### Ute Pass Mini Storage, AL-18-010

Please accept the following comments from El Paso County Public Health (EPCPH) for the project referenced above:

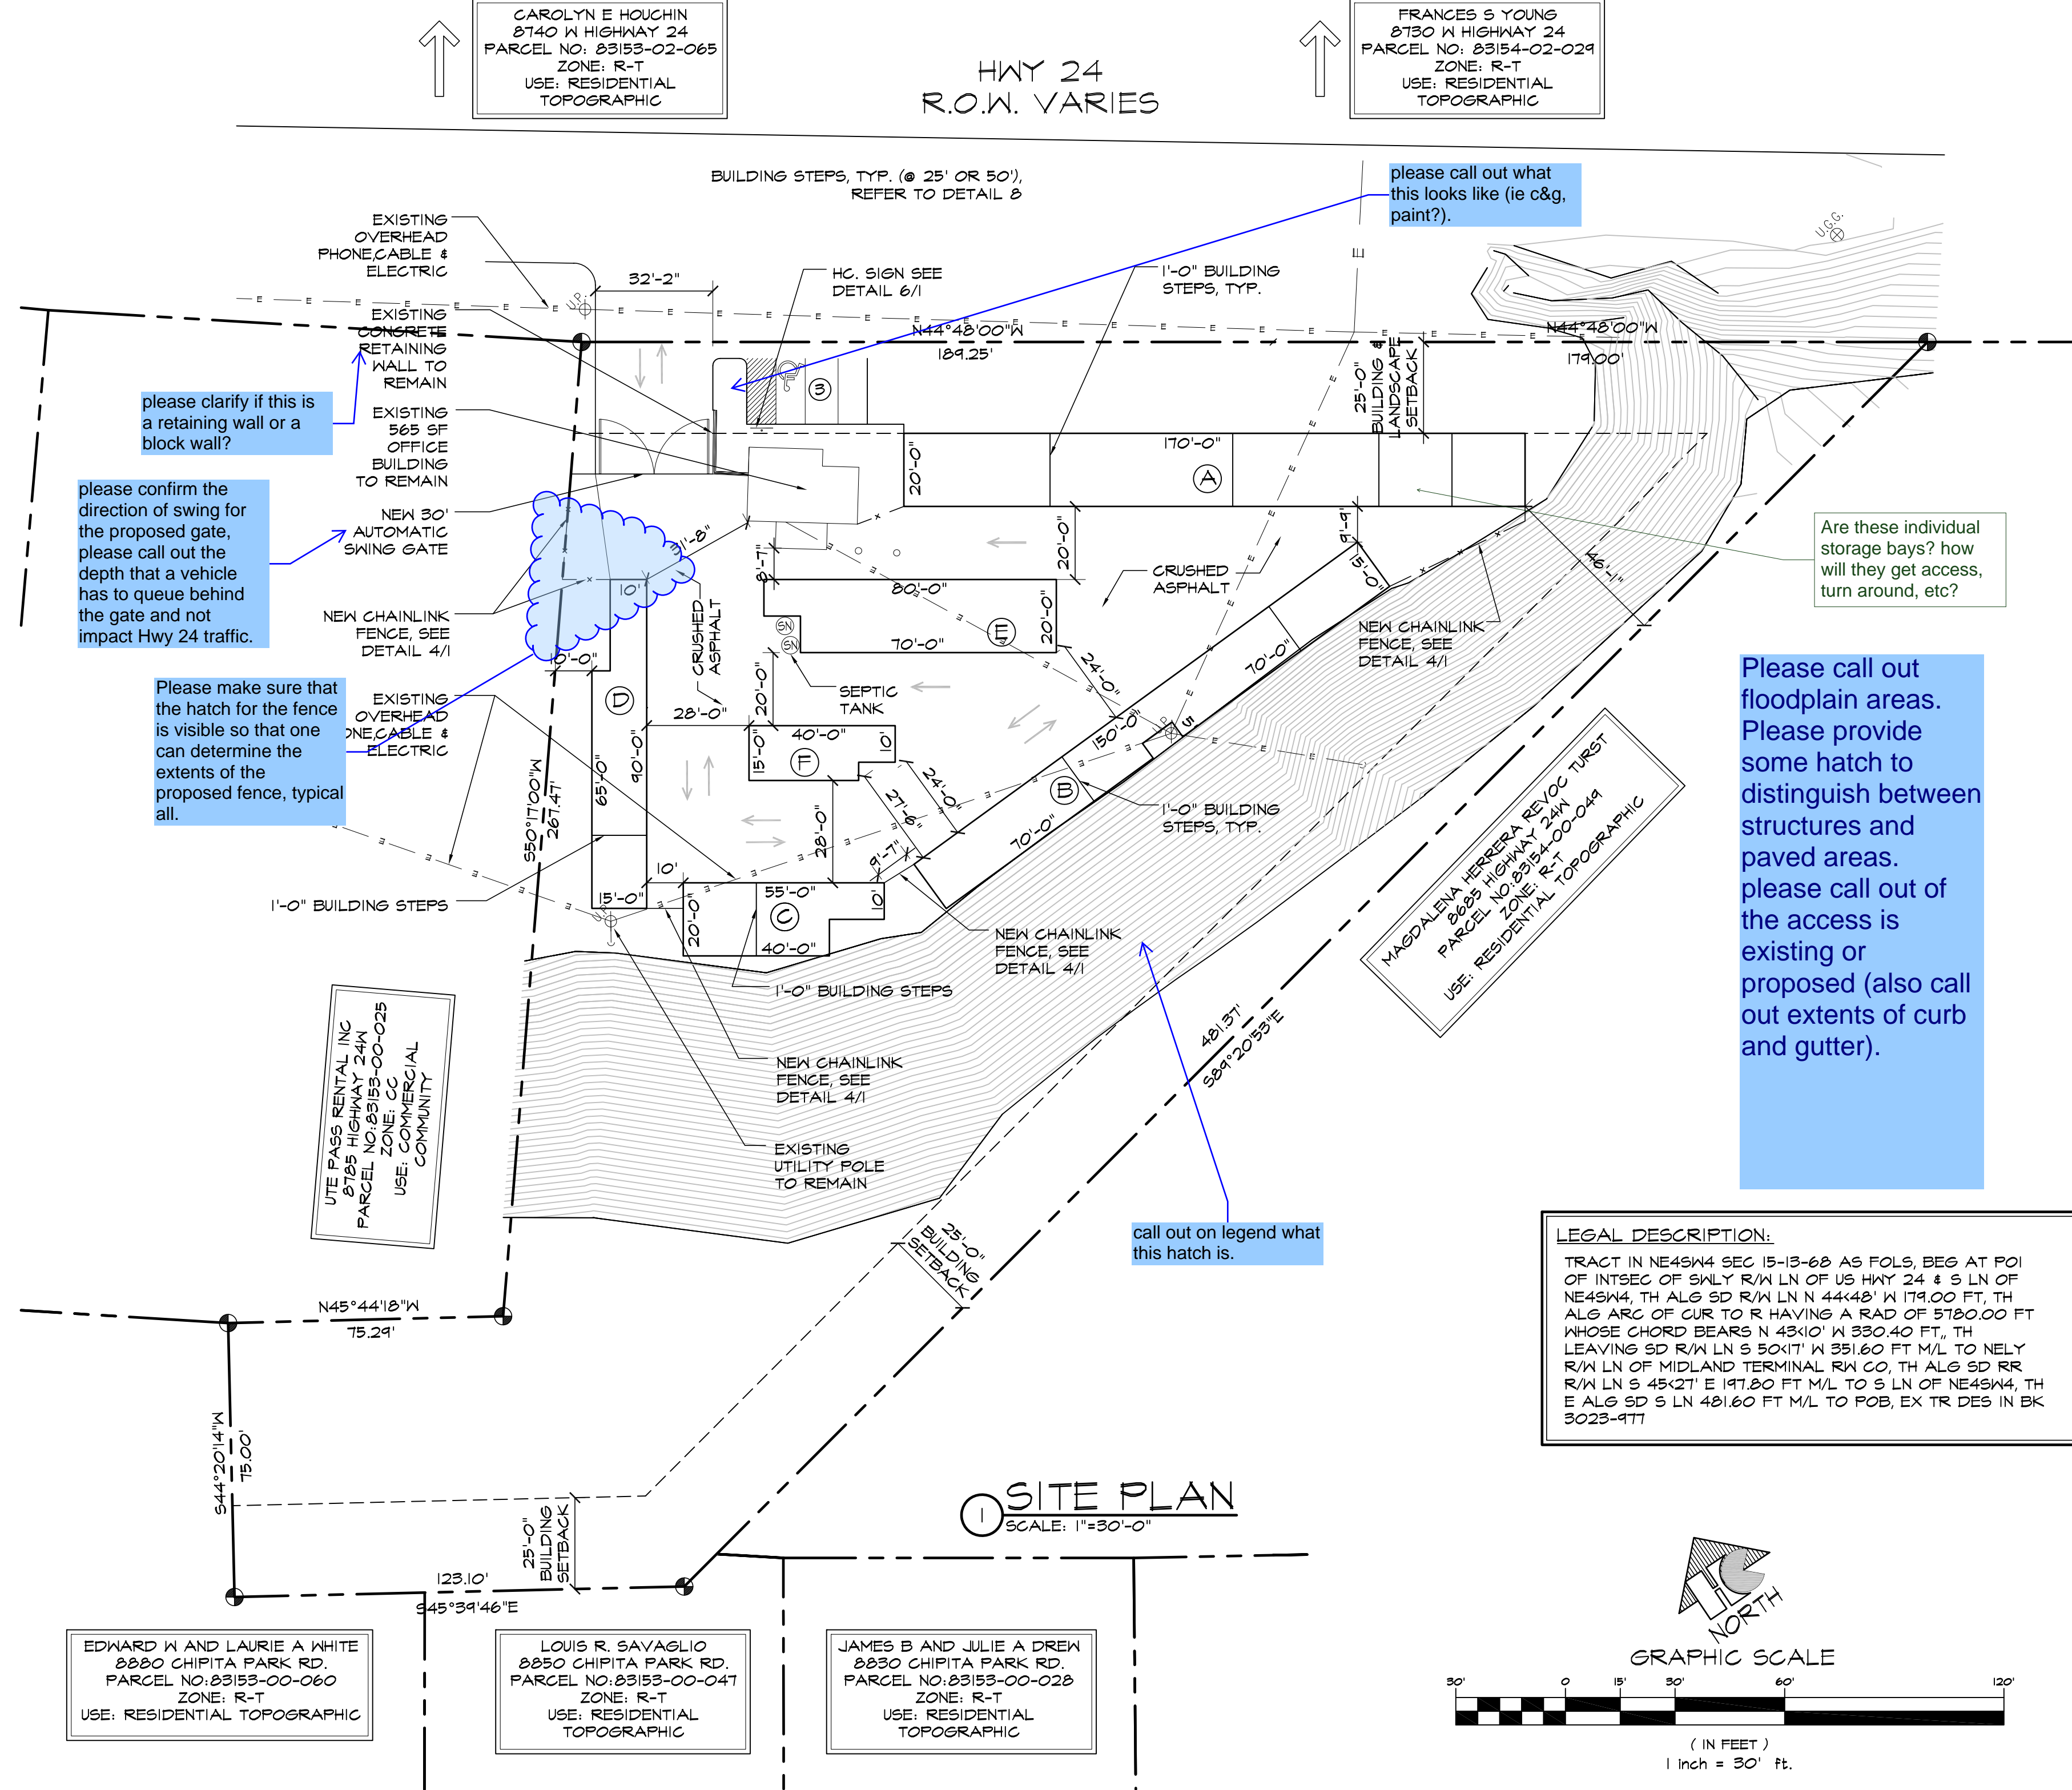
- The site development plan showed the location of a septic tank on the property, but not the soil treatment area (STA). The STA must be located and protected from compaction associated with construction traffic, building construction and parking. Locating the STA, which is likely a deep seepage pit/drywell is essential for safety reasons as well as for public health reasons.
- El Paso County Public Health does not have a record of the OWTS installed on the property; however, EPCPH did not require records or permits until 1966, and the existing structure was built in 1955.
- If earthmoving activities for the project exceed 1 acre, then go to EPCPH for a Construction Activity Permit:  
<https://www.elpasocountyhealth.org/service/air-quality/construction-activity-application>
